Sub plans

I have received the attached acknowledgment letter for the application at 14-16 Anchor Springs and understand that you are the case officer for the application.

PROPOSED FLOOR PLAN

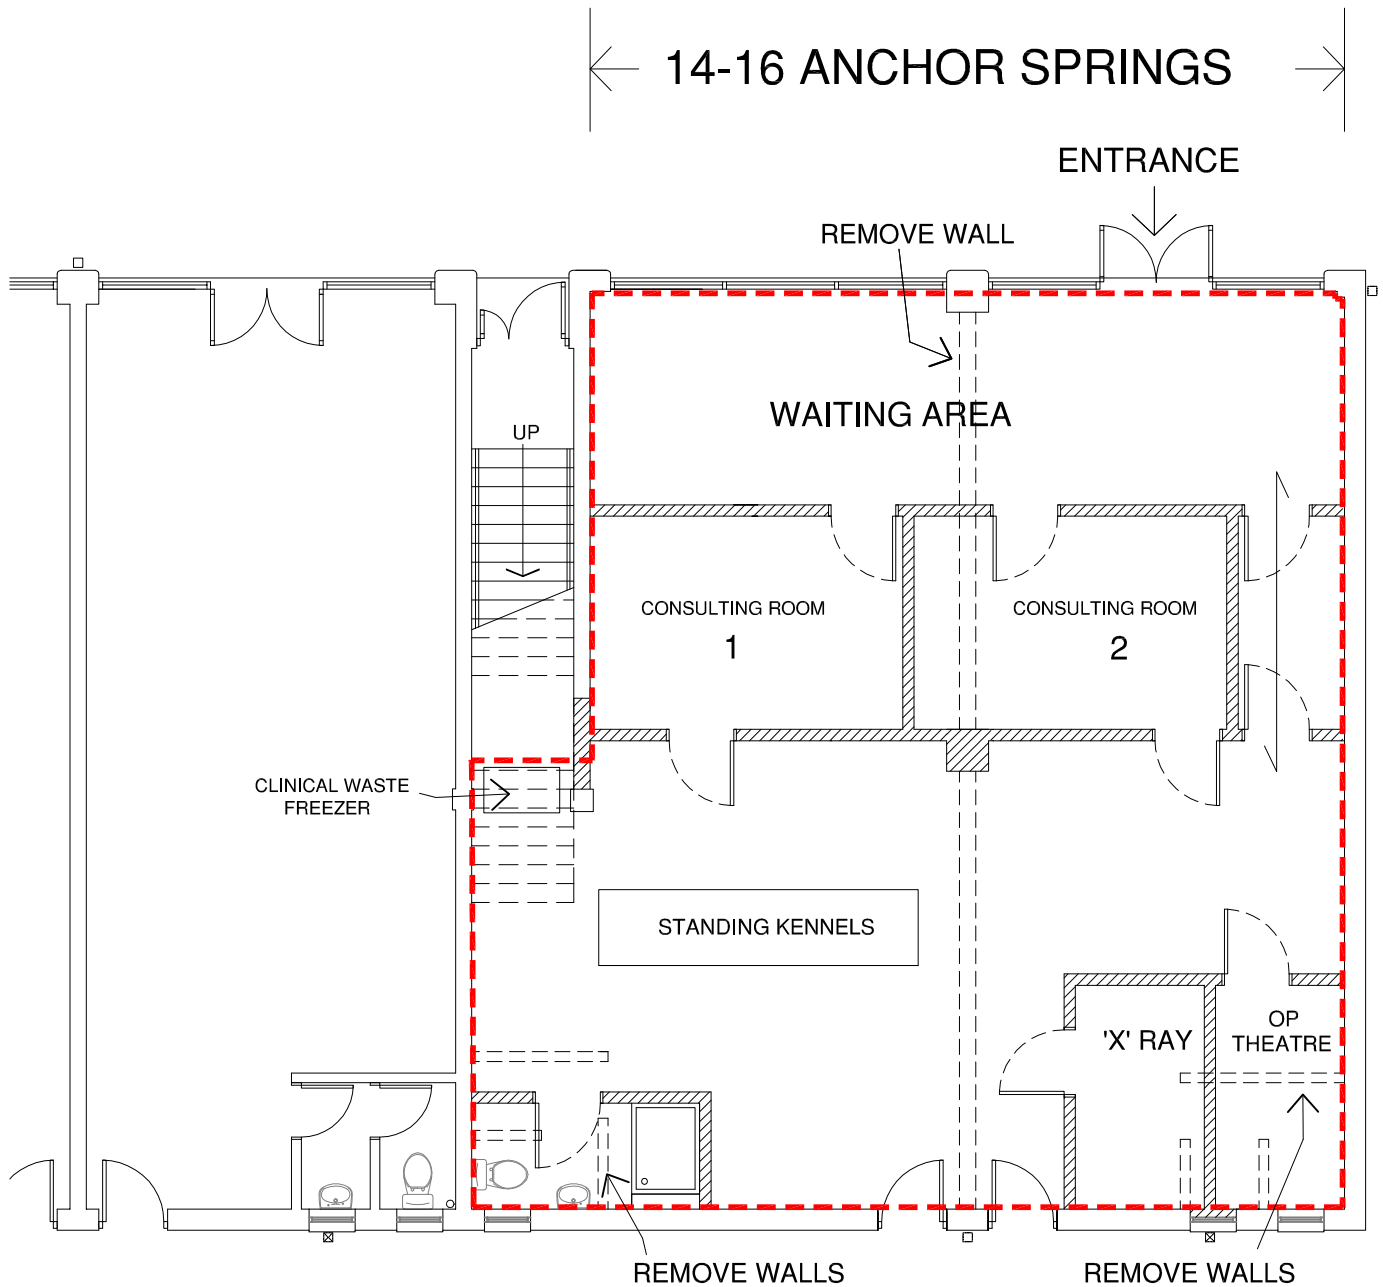
Further to the recent request for information relating to the location of the clinical waste freezer, I attach amended plans demarcating this. In addition, I can confirm that no extraction units are proposed.
